Application for Planning Permission for Works or Extension to a Dwelling

Development: Proposed First Floor Extension, including internal and external alterations.
Location: 36 Southdean Drive Middleton-On-Sea PO22 7SX

ADDRESS: 36 Southdean Dr, PO22 7SX	SCALE: As Shown @ A3	DATE: 30/06/26
DRAWING: Location & Block Plans	DRAWING NUMBER:	00B
A:	14 Cambridge Court, Cambridge Road, Puckeridge, SG11 1SB	
T:	07944211585	
E:	info@wall2wallplanning.co.uk

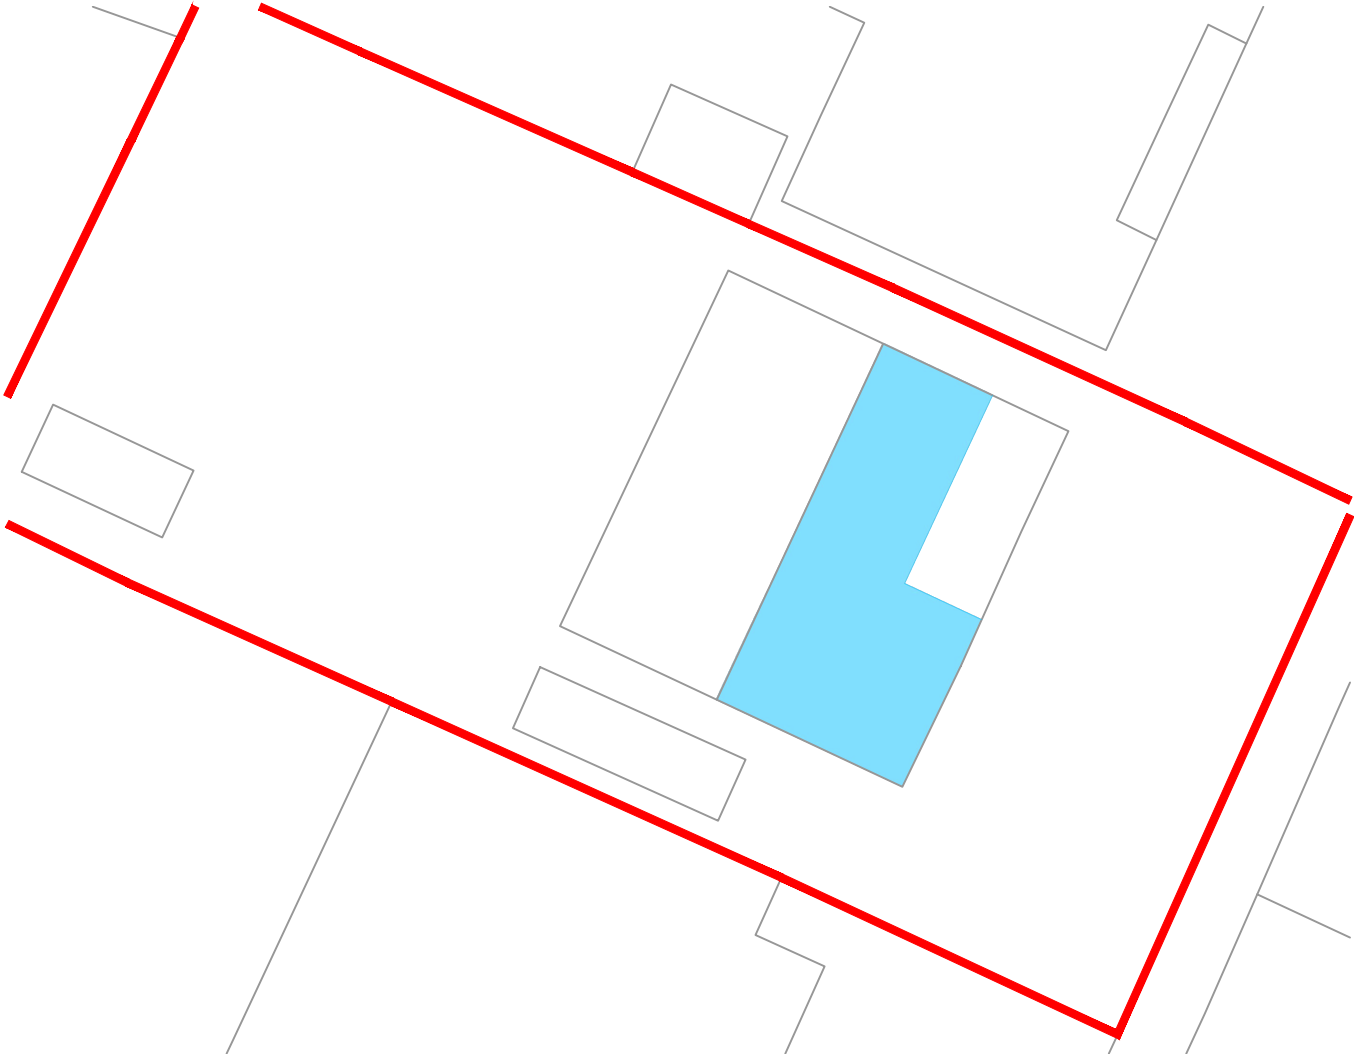
Scale bar for 1:1250 is not consistent with given scale on drawing 00. Please amend.
